31 October 2014

Application for the Yorkshire and Humber Carbon Capture and Storage (CCS) Cross Country Pipeline Development Consent Order (Reference: EN070001)

In advance of the Preliminary Meeting for the above project and as discussed with Sarah Jones and Iwan Davies, we request that four small changes are made to the application documents. These changes, and the reasons for them, are set out below.

**BARMSTON PUMPING STATION  
 PARAMETER PLAN**

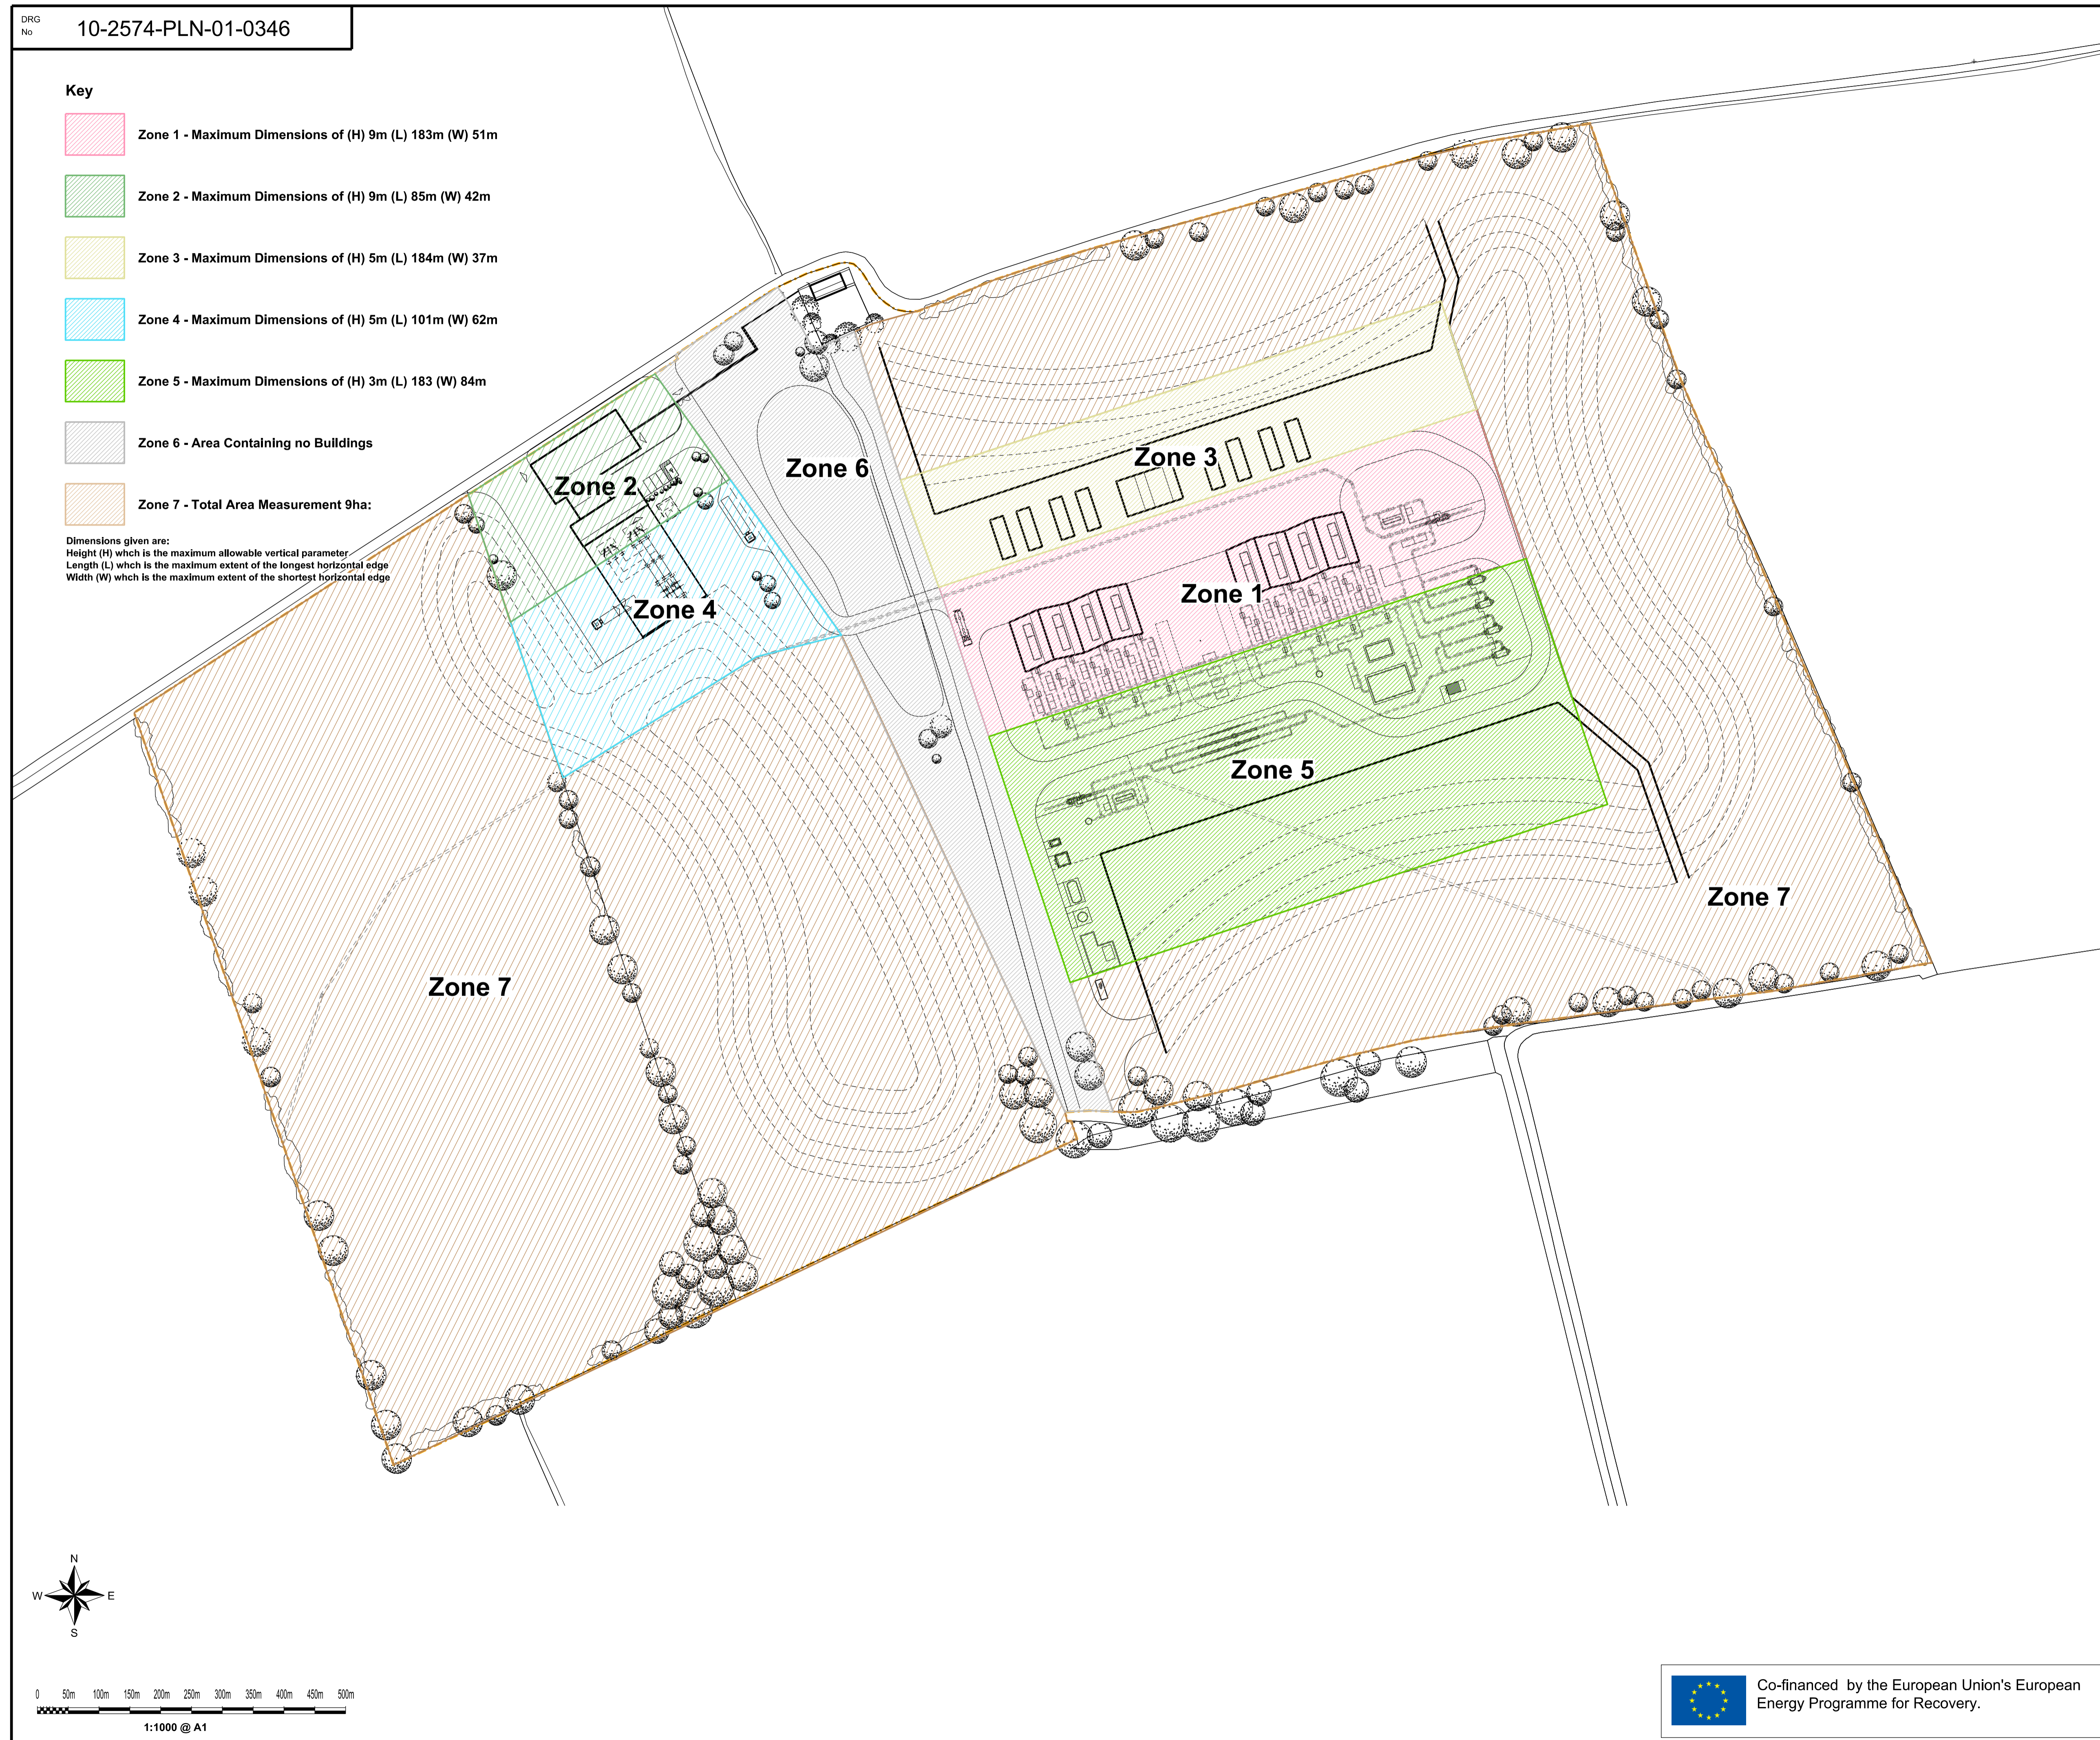
It has come to our attention that when this figure was assembled the identified zones were misaligned to the background engineering drawing. The consequence is that for accuracy the position of the zones need to be modified. At present, the vent stack (illustrated as the 'vent station area' on figure 8.7 of the Design and Access Statement) is shown as being in zone 5, but should in fact be within zone 1, which is the zone adjacent and to the north of zone 5. Zone 1 allows for development of sufficient height to accommodate the vent stack.

As is clear from the text at paragraph 8.2.24 (pg.45) of the Design and Access Statement and paragraph 4.6.20 (pg.36) of Chapter 3 of the Environmental Statement, the height of the vent stack is 8m and so must sit, and was intended to sit, in zone 1 which has a sufficient vertical height parameter.

The replacement parameter plan shifts zones 3, 1 and 5 to the south. There is no change to the underlying indicative design detail or location of the apparatus/buildings nor the sizes of the zones. There is no change required to the text of either the Design and Access Statement or the Environmental Statement.

- A replacement parameter plan to be used in place of the three plans referenced above. This is described as document 2.14 Revision B and dated October 2014)
